Observations By:	Mike Hibbert, KC Waste Strategy(Refuse & Recycling)
Application No.	2023/90348
Proposed Development:	Erection of community sports complex (within a Conservation Area)
Location:	Former Hillhouse Bowling Club, King Cliff Road, Birkby, Huddersfield, HD2 2RR
OS Map Reference	SE 414167.465 418135.2004
Applicant/Agent:	Acumen Designers & Architects Ltd
Class:	Small Major Developments

**Consultation Response from Mike Hibbert,
KC Waste Strategy(Refuse & Recycling)**

Responding Ref: WPS 23-19

GROUND FLOOR
 1 : 200

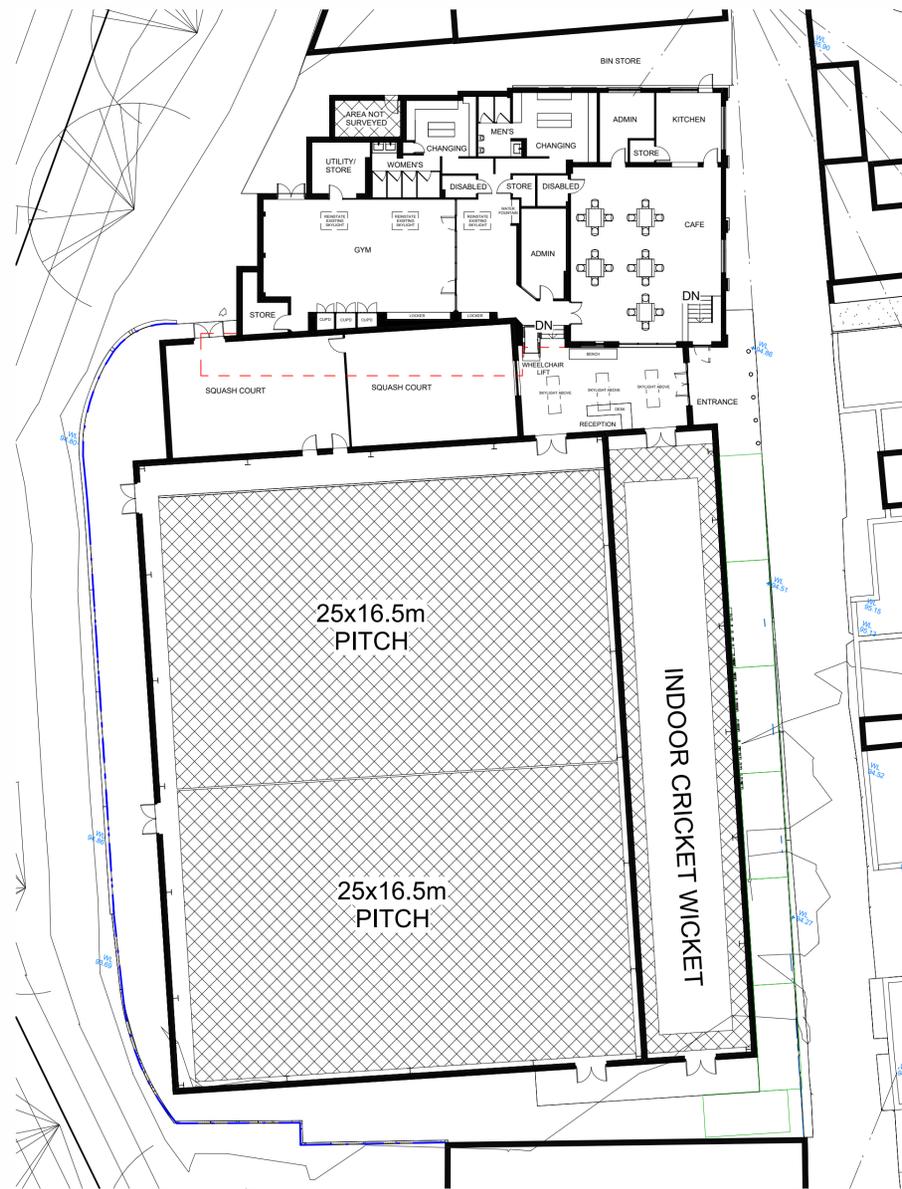
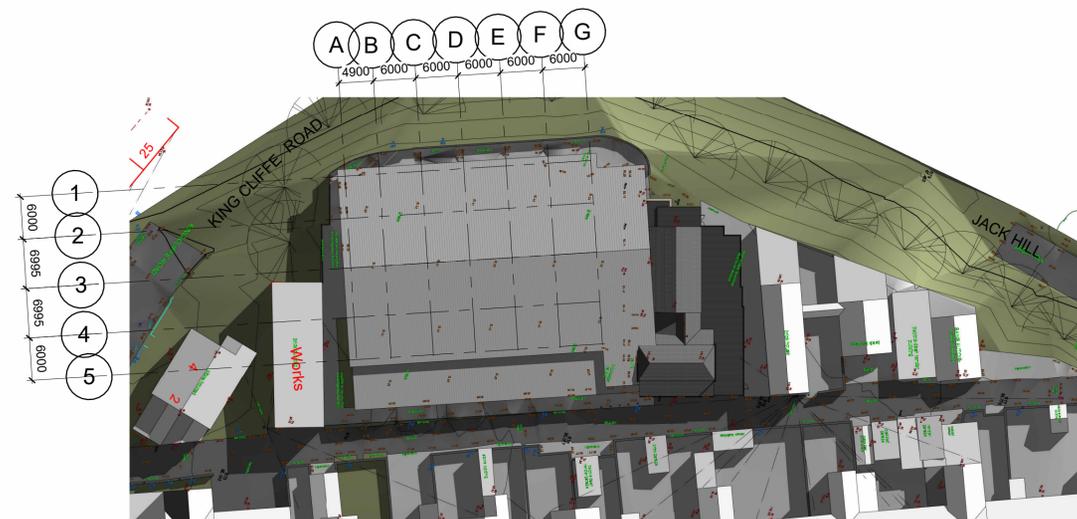
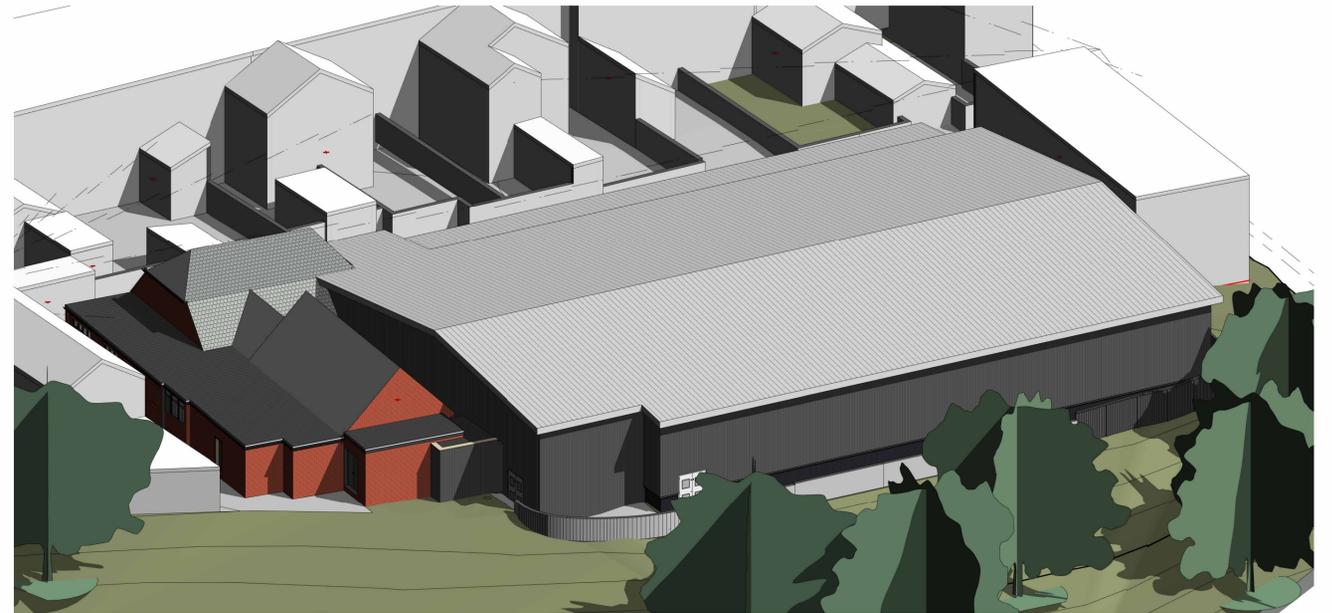
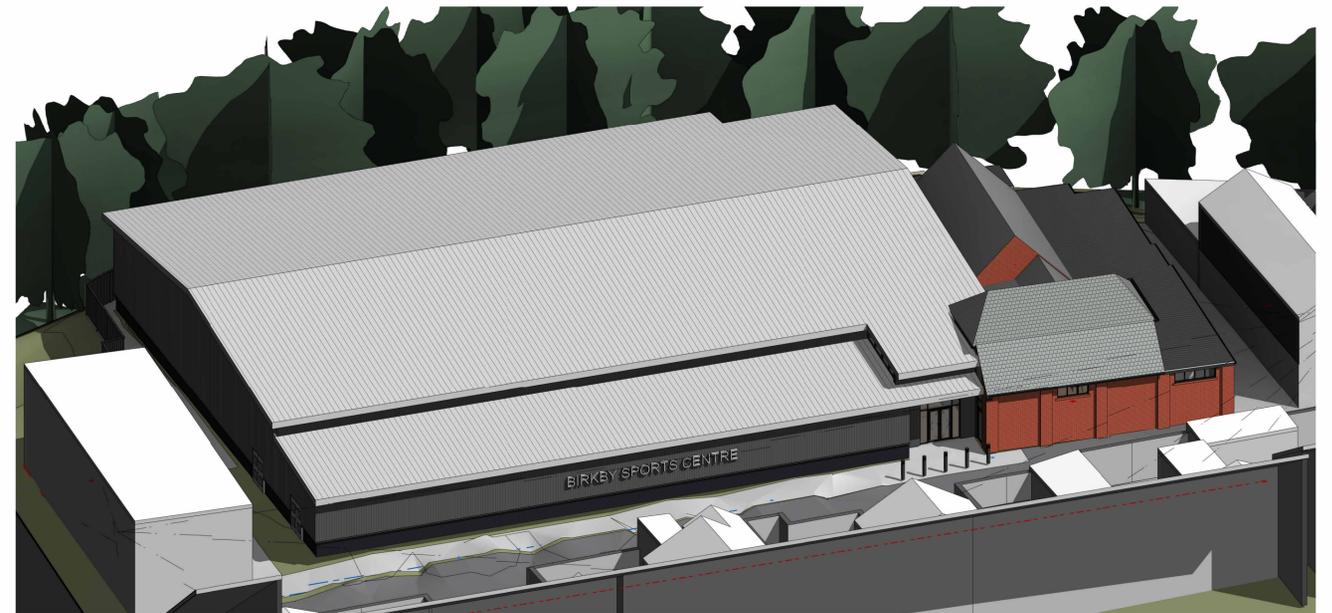
Details of the new building are shown on PROPOSED PLANS & 3D Dwg (100)02 dated JAN'23. The location of the proposed bin store is shown on the plan to the North of the buildings in proximity with the kitchen. The application form states Bin Storage is provided but does not include any details on waste storage or collection.

- Guidance indicates the floor space for 1100ltrs wheeliebins is 1575mmx1190mm with space required to manoeuvre the bins within the store.
- The waste storage area should be secure to prevent unauthorised use, damage or theft. The doors to the bin store should be secured but enable access by facilities management and collection staff. The external doors need to be wide enough to enable a wheeliebin to pass through. Collection staff will require details of a keypad code if used to secure the store.

- Waste storage presents a fire risk. Any wheeliebin storage locations should be carefully considered when undertaking a fire risk assessment and may need relocating away from buildings. Guidance indicates the store must be either 6m away from the building or be constructed of suitable material to contain and prevent the spread of fire. See BS5906:2005, Building Regs 2010 Part H6 and CFWA-E Guideline No 7:2022 F.
